BUILDING CODE OF AUSTRALIA ASSESSMENT REPORT

Proposed Roche Facility 20 Reconciliation Drive Greystanes

Dated: **7 December 2012**

Prepared for: **Dexus**

**Site Plan**  
 scale 1:400 @ B1  
 December 2012  
**4047\_DA-002**

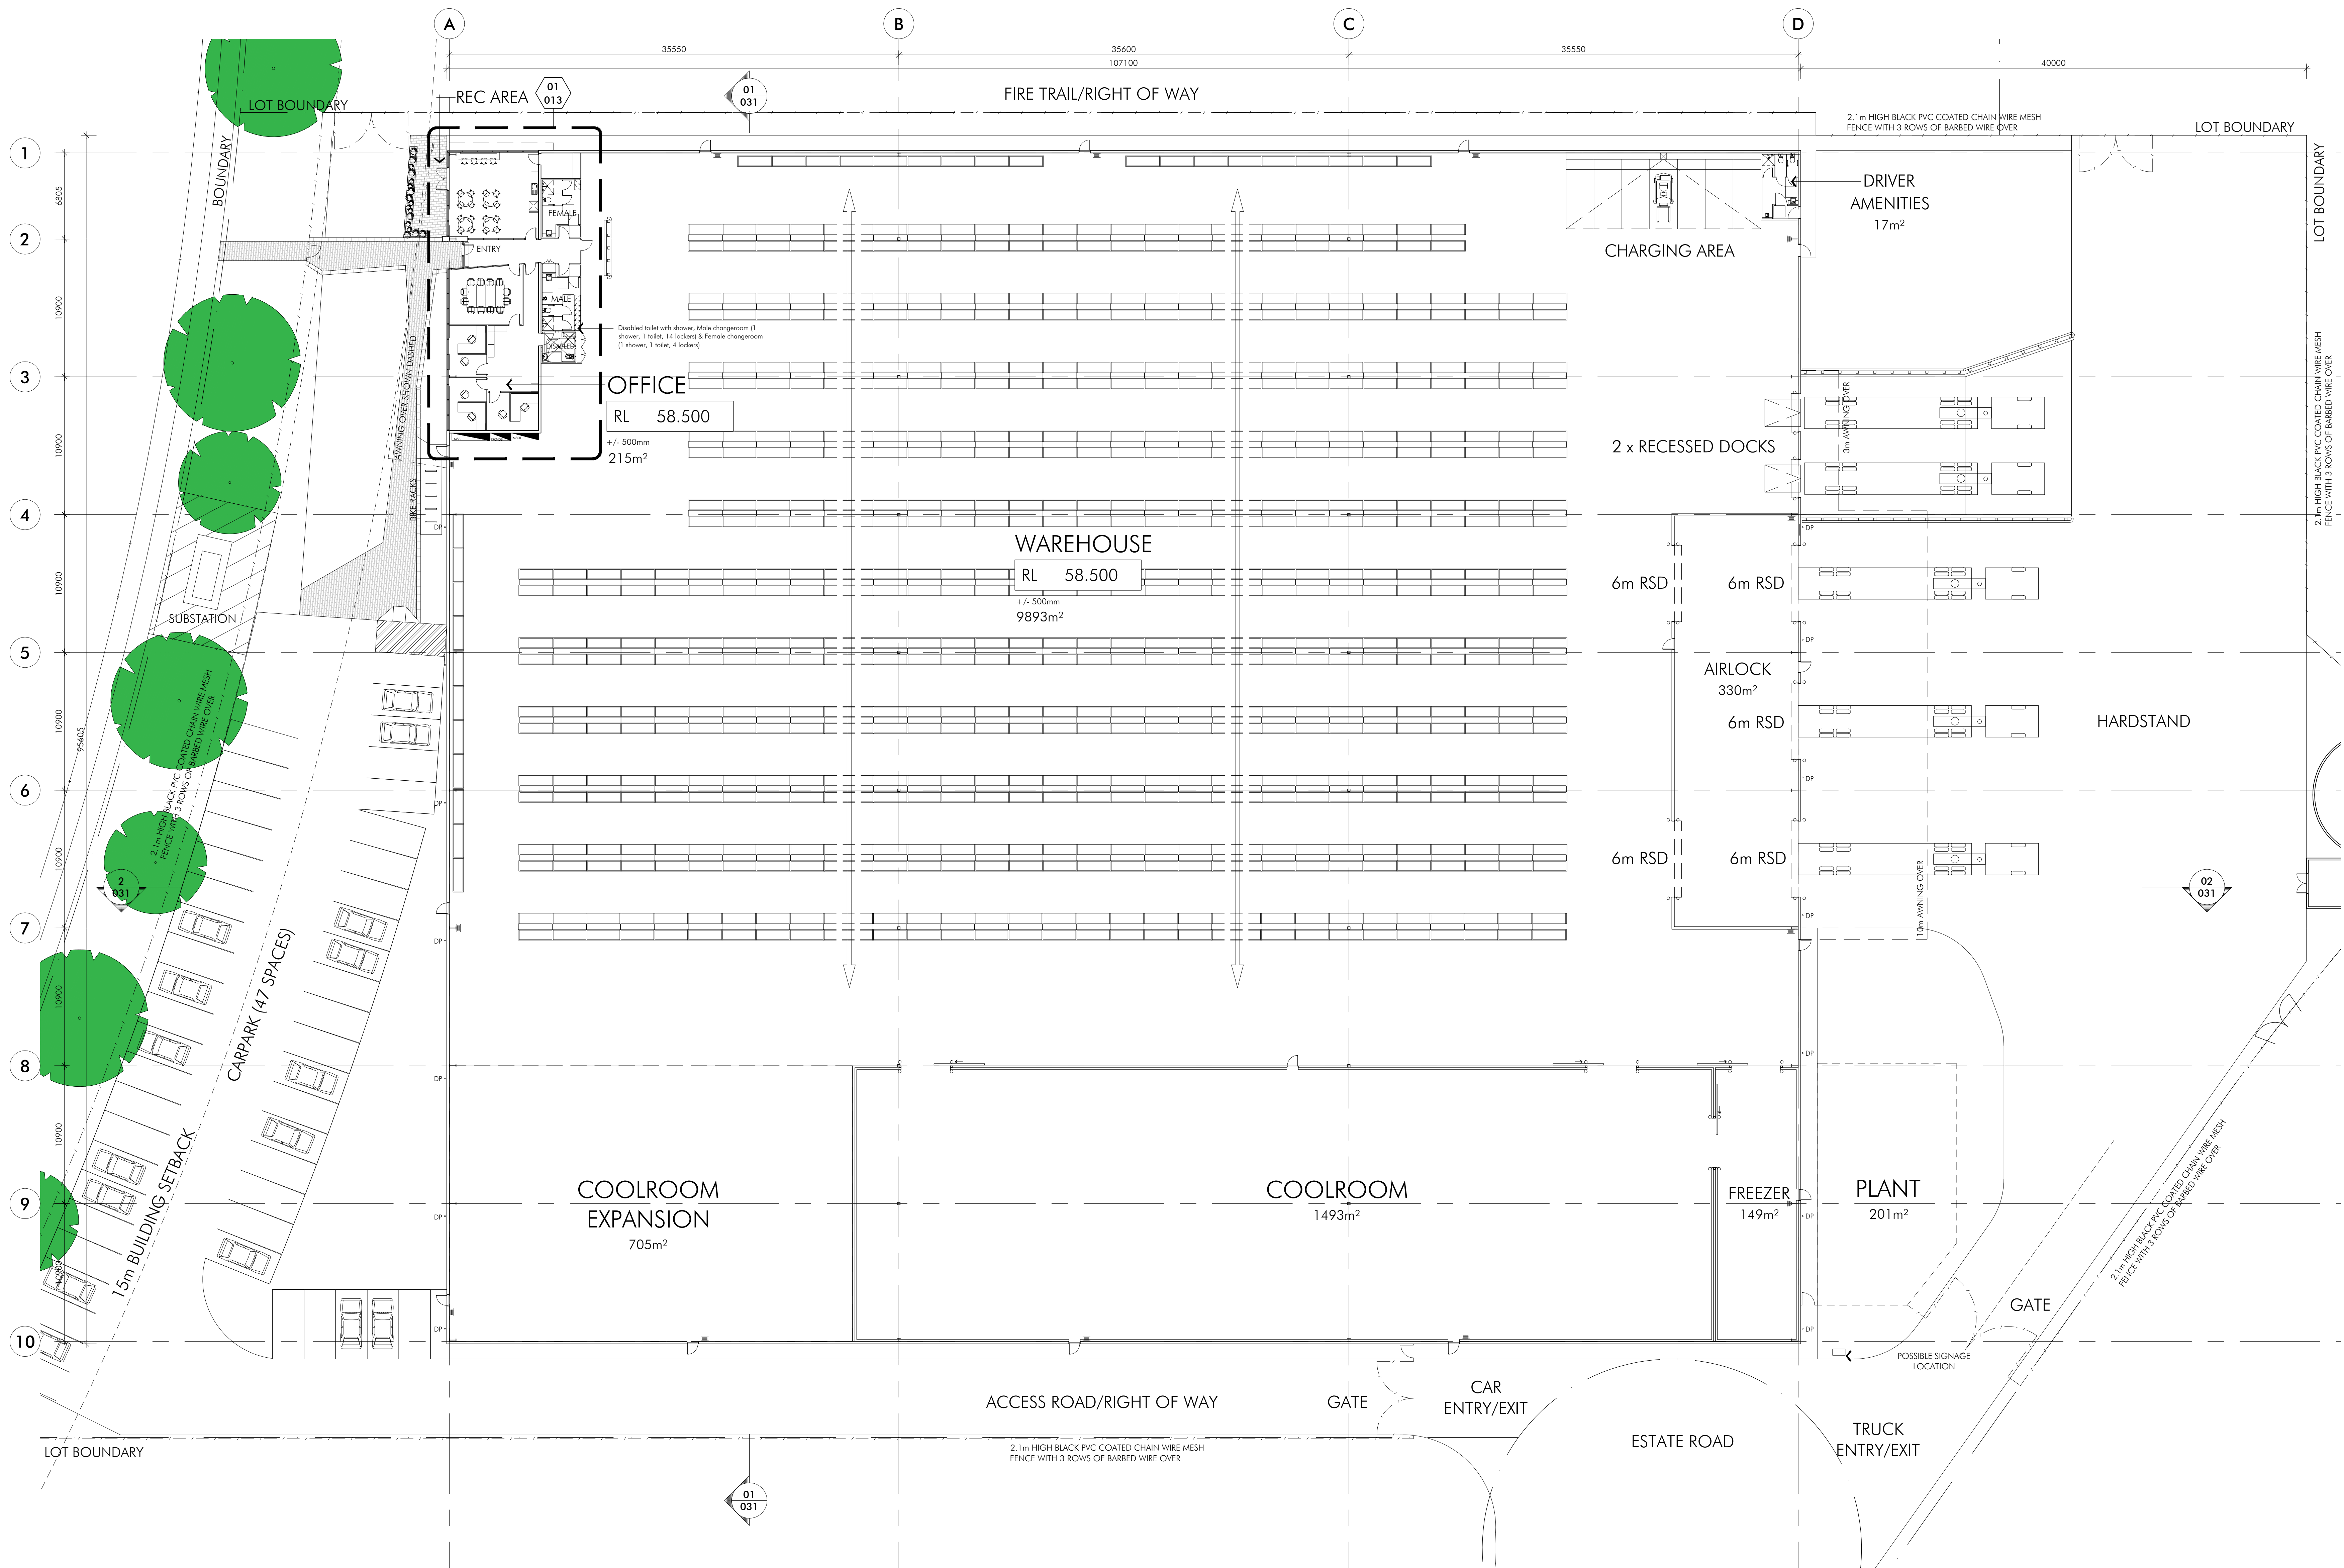
DTS Clause	Items to be addressed as part of Design Development	Performance Requirement
C2.4	Perimeter vehicle access is provided to the facility on three sides with the northern elevation provided with pedestrian access only. As per the requirements of Clause C2.3 and C2.4 of the BCA, the access to the North elevation of the site, will be required to be addressed in accordance with Performance Requirement CP9 of the BCA, and included within the Fire Engineered Solution for the development.	CP9
D1.4 and D1.5	A maximum distance of 80m to an exit and 100m between alternative exits has been identified. Therefore as part of the Fire Engineered Solution for the development, the above will be required to be assessed in accordance with Performance Requirement DP4 and EP2.2 of the BCA.	DP4 and EP2.2
C2.3 and Table E2.2	Smoke Hazard management system serving the development will be required to be assessed as part of the fire engineered solution in accordance with performance requirement CP9 and EP2.2 of the BCA.	CP9 and EP2.2

Please note as part of the Fire Engineered Solution for the development, the non-continuous perimeter vehicular access trail to the North East corner of the site will be required to be addressed as part of the Fire Engineered Solution in accordance with Performance Requirement CP9 of the BCA.
